Addendum No. 1

RE: Contract # C204108

Johnston County (R-3825B)

NC-42 From East of SR-1902 (Glen Laural Road)

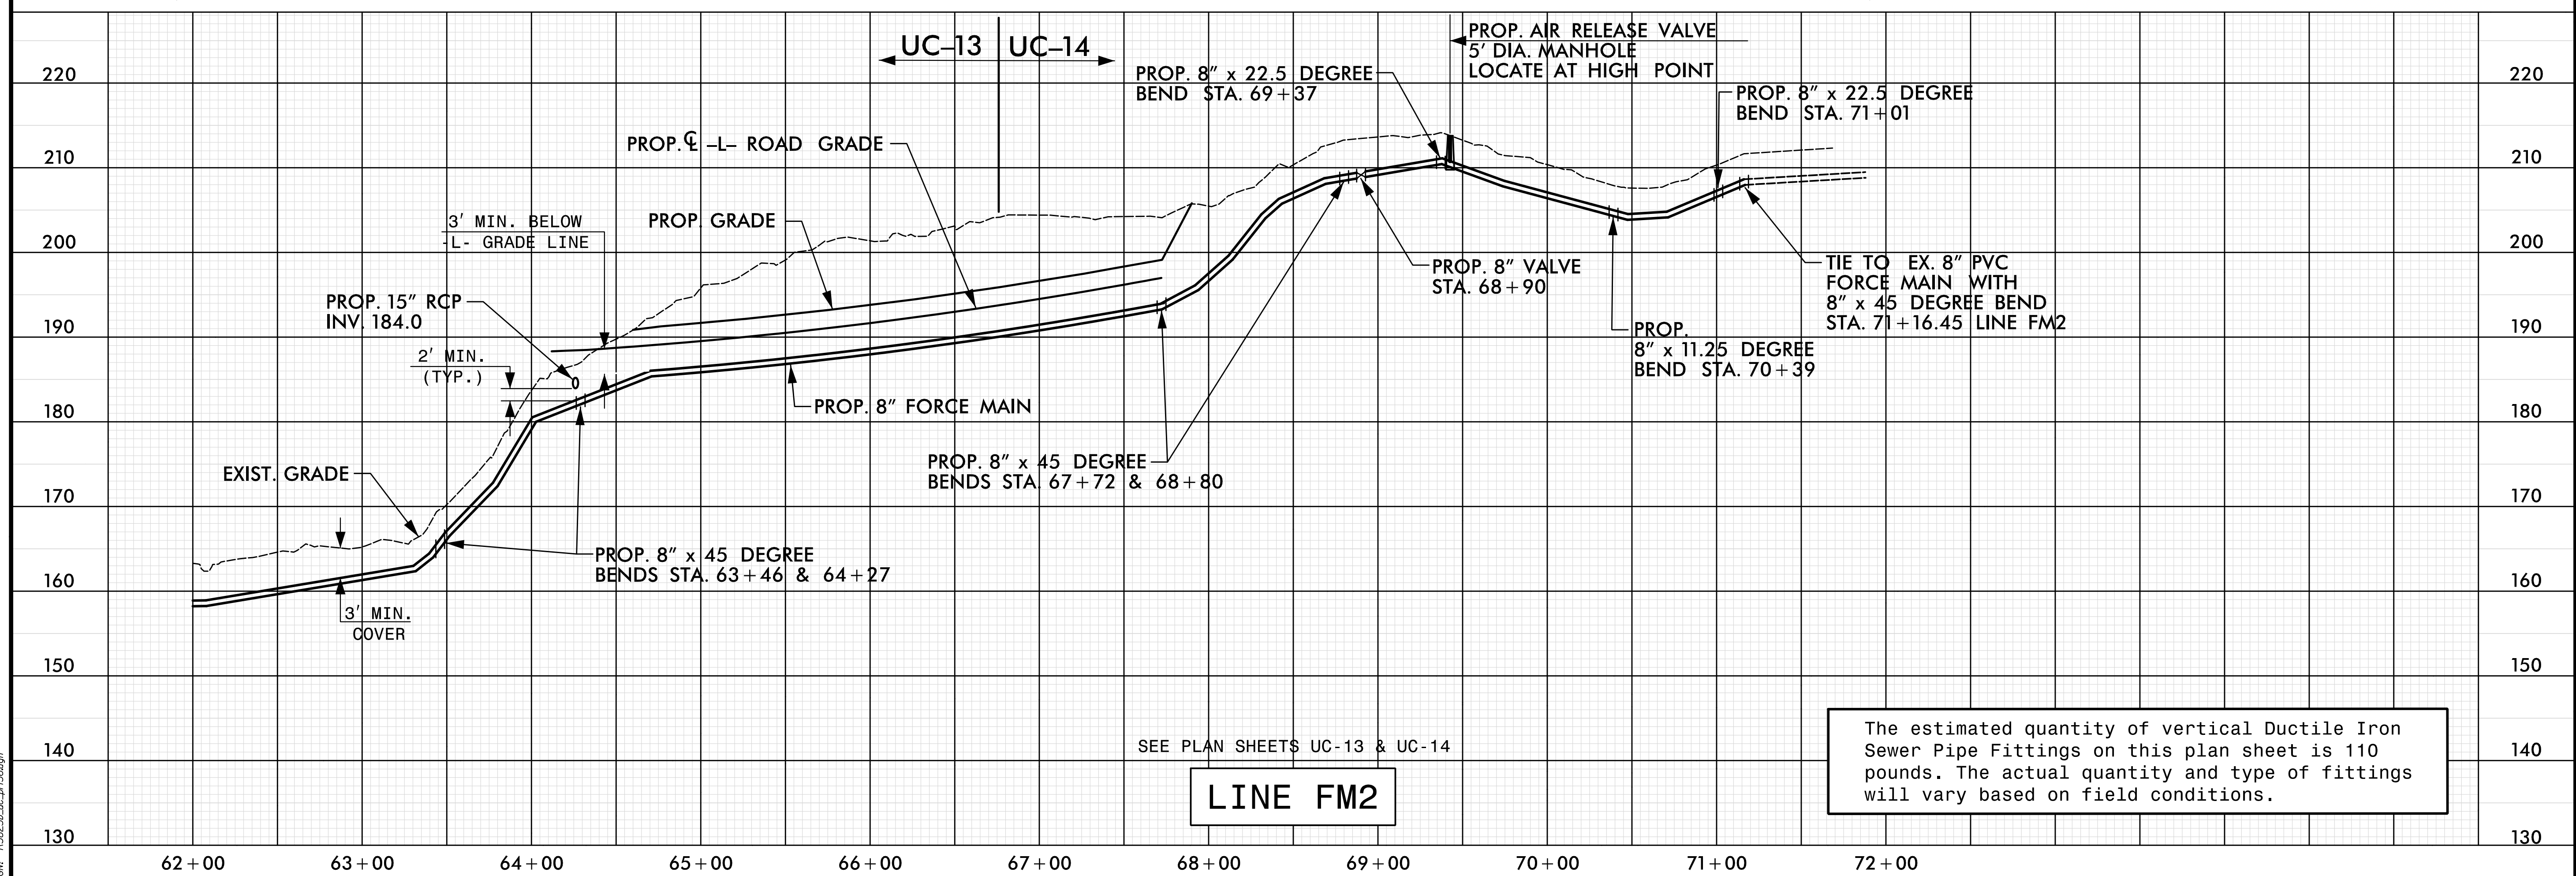
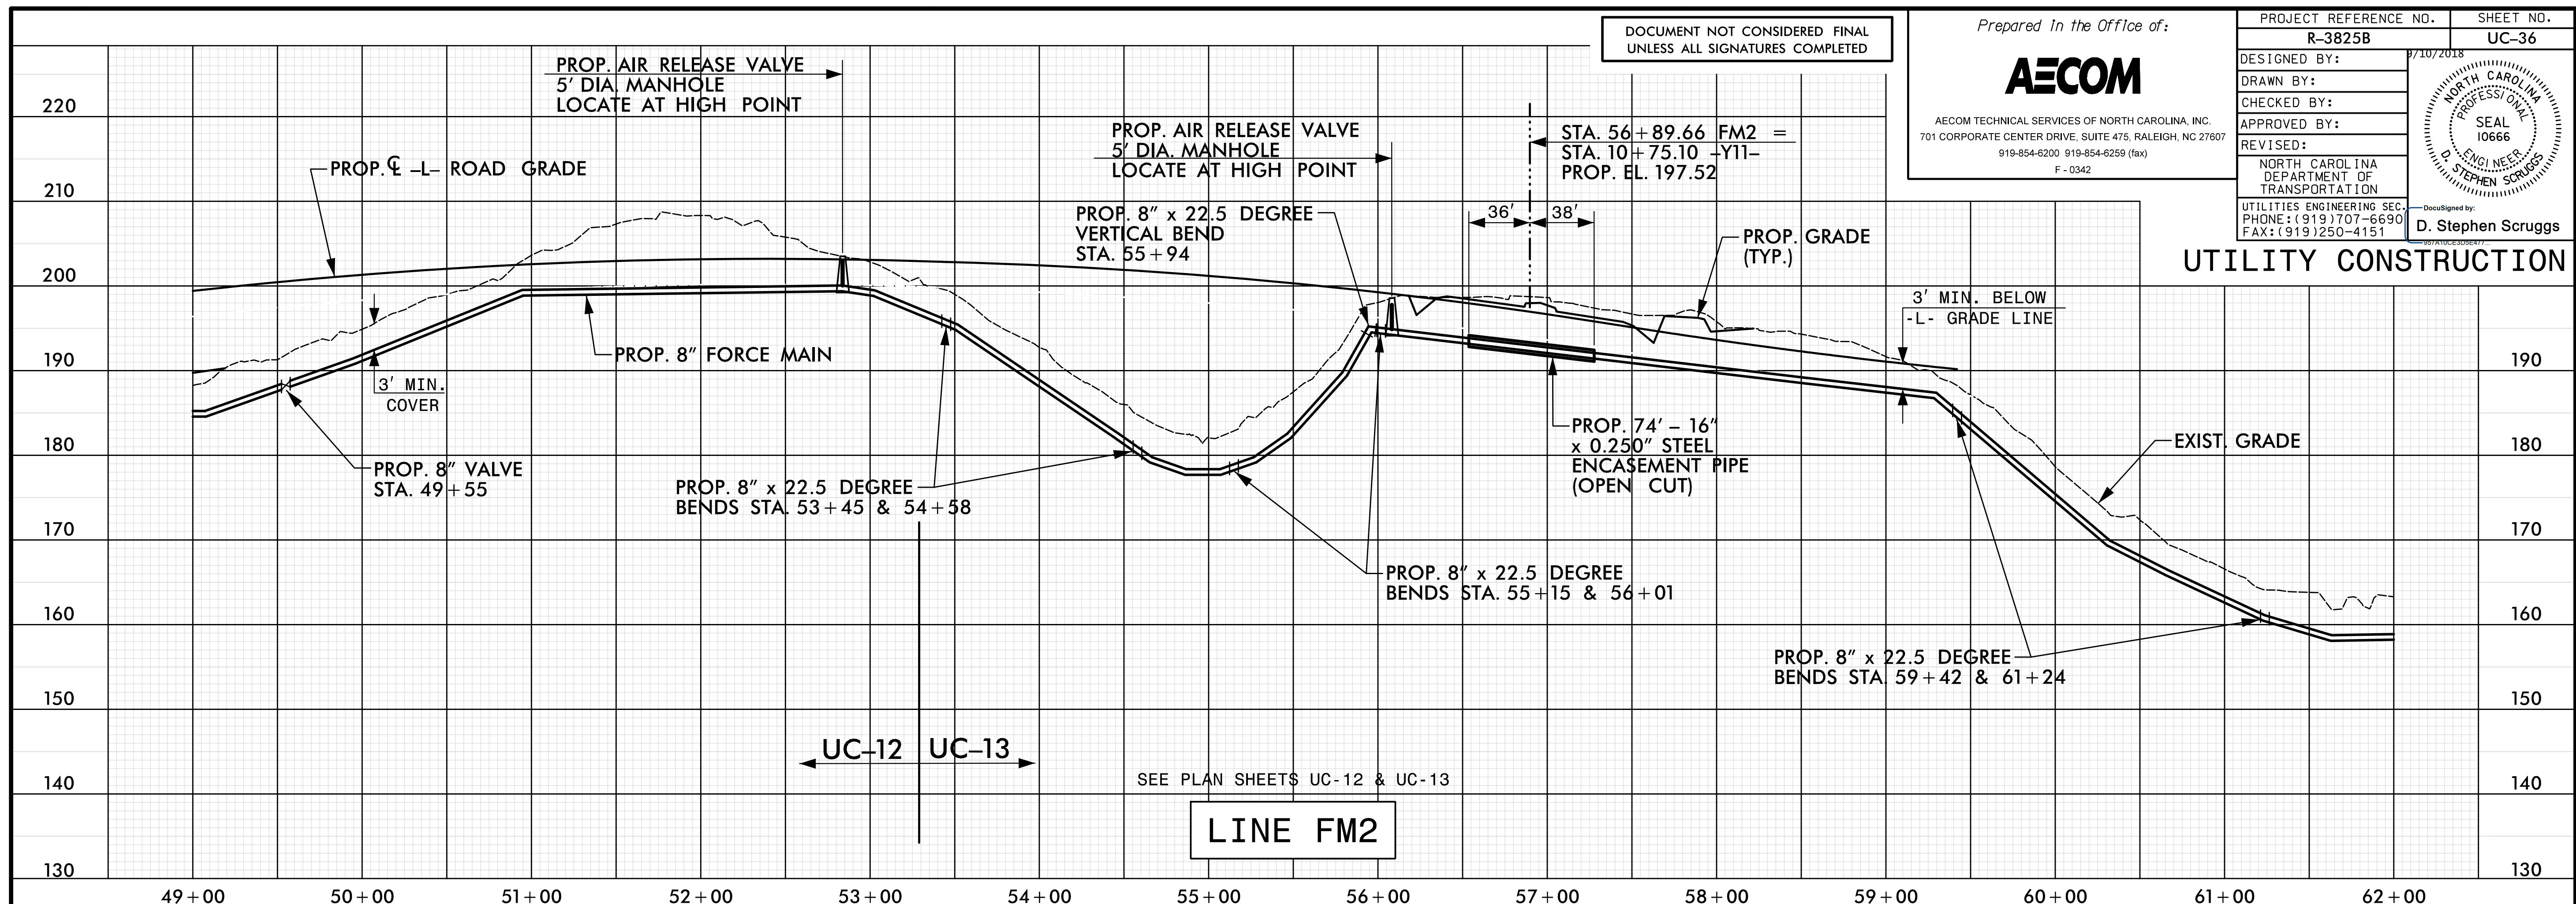
Sheet No.	Revisions
2A-1	Added Match Line A and B on Typical No. 2
2A-2	Added Temporary Pavement Widening Detail
TMP-1B	Revised the third "Management Strategies" note for "-L- (NC 42)"
UC-4	Revised to remove "Relocate Fire Hydrant" and added a new "Fire Hydrant"
UC-5	Revised to add two 24" Valves, one 8" Valve and one 8" Linestop
UC-6 and UC-7	Revised to remove "Relocate Fire Hydrant" and added a new "Fire Hydrant"
UC-9, UC-10, UC-12 and UC-14	Revised to remove "Relocate Fire Hydrant", added a new "Fire Hydrant" and new 8" Valve
UC-15, UC-19, UC-20 and UC-22	Revised to remove "Relocate Fire Hydrant" and added a new "Fire Hydrant"
UC-25	Revised to show proposed Tees and 24" Valves
UC-34	Revised to show newly proposed 8" Valves and encasement pipe
UC-36	Revised to show newly proposed 8" Valve
